Preliminary Acceptance Punch List

6-17-2024
Bike Shop in Struthers Ranch Filing 4 (Polaris)
PPR2248
Hammers Construction
1411 Woolsey Heights
Colorado Springs, CO 80915

**Polaris ATV Shop
Punch List of Deficiencies
Per Approved Plans
6/17/2024**

6 PEDESTRIAN RAMP DETAIL D-8J
 SCALE: 3/16"=1'-0"

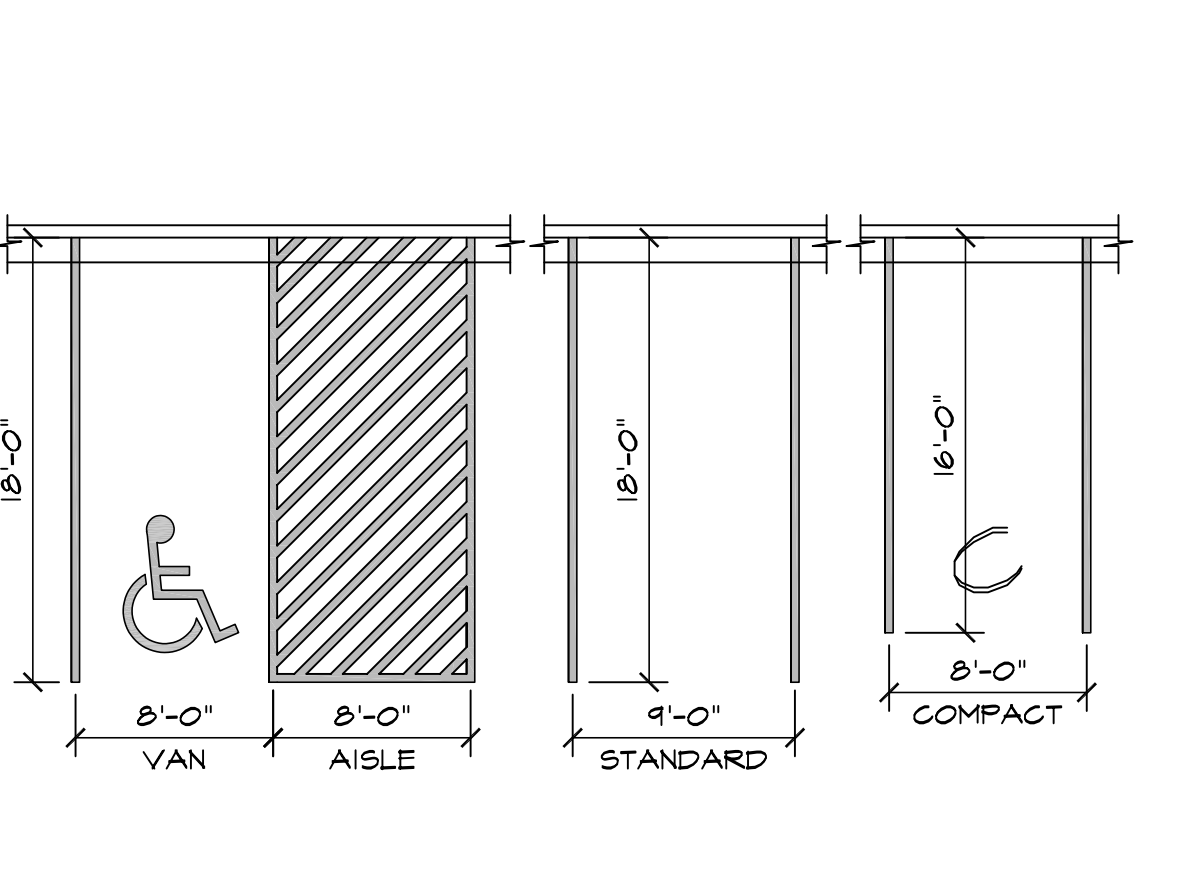
- Remove and replace cracked ADA wing on the southwest ramp.
